Application for a non-material amendment following a grant of planning permission.

Relocation of a new fence to a new private garden to 71 Upper Bognor Road that will create separation from the wider University campus.

5542-100-D3 Site Plan Proposed

5542-100-D5 Site Plan Proposed

Drawing no.
5542-100-D5

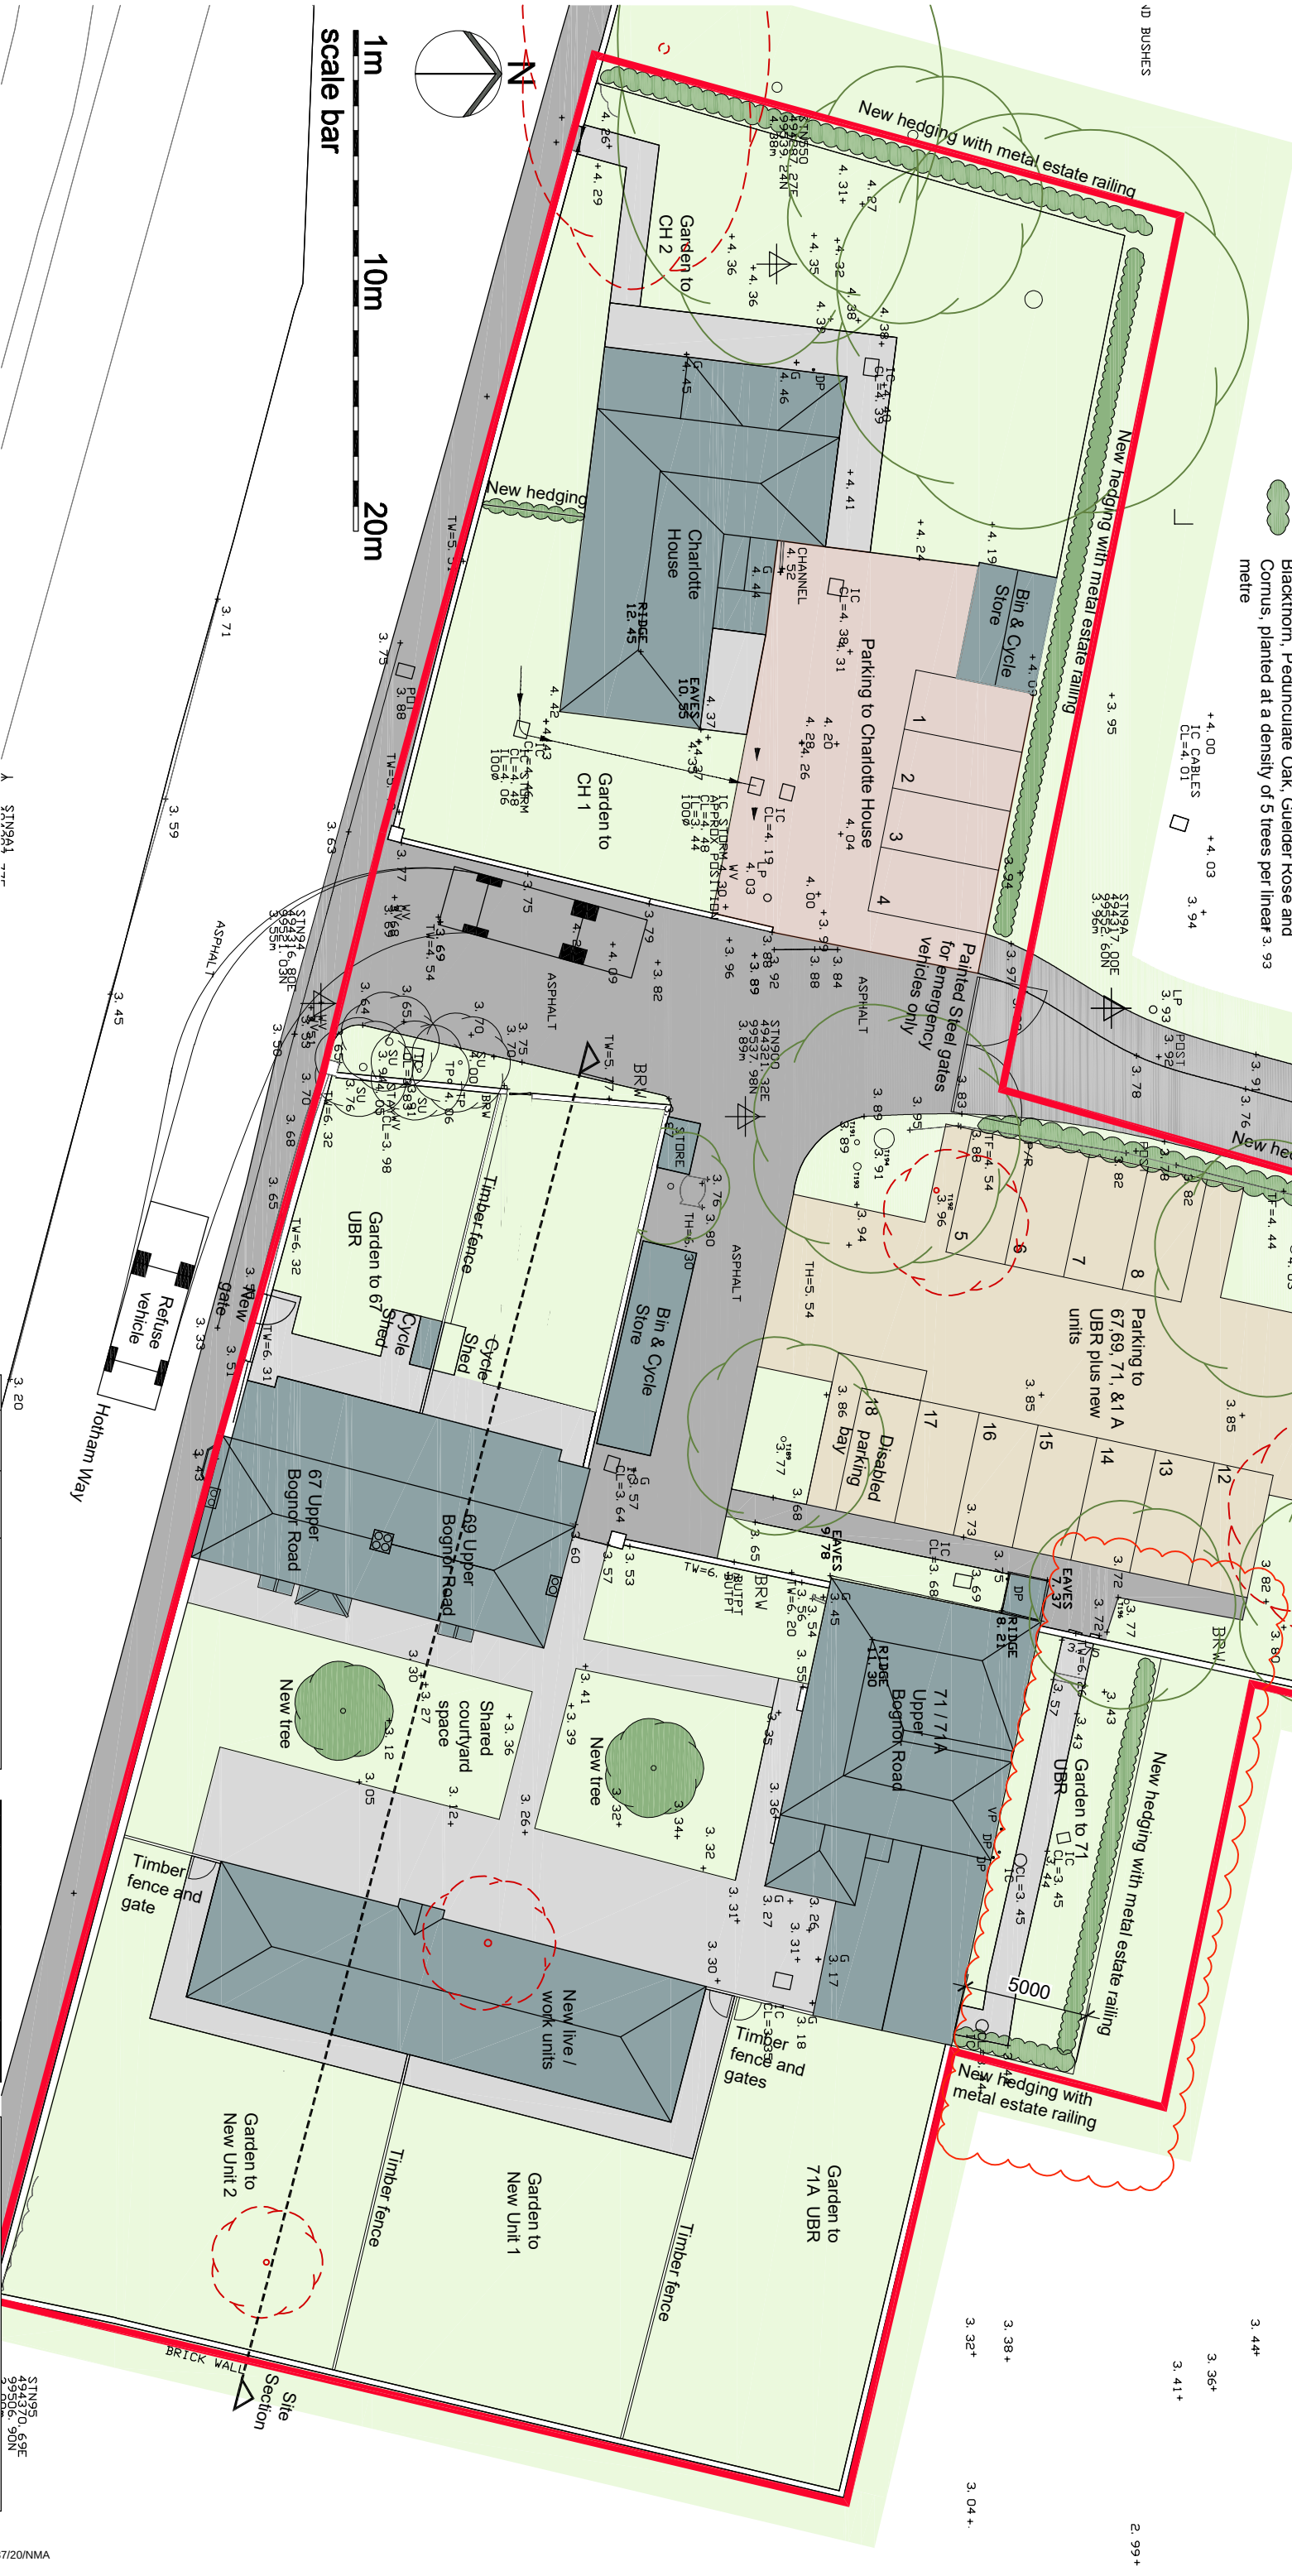
The fence was shown in the wrong location in the original application. It was shown 8.5m north of the north facade to 71/71A Upper Bognor Road when the intent was it should be 5.0m north of the north facade to 71/71A Upper Bognor Road as now indicated.
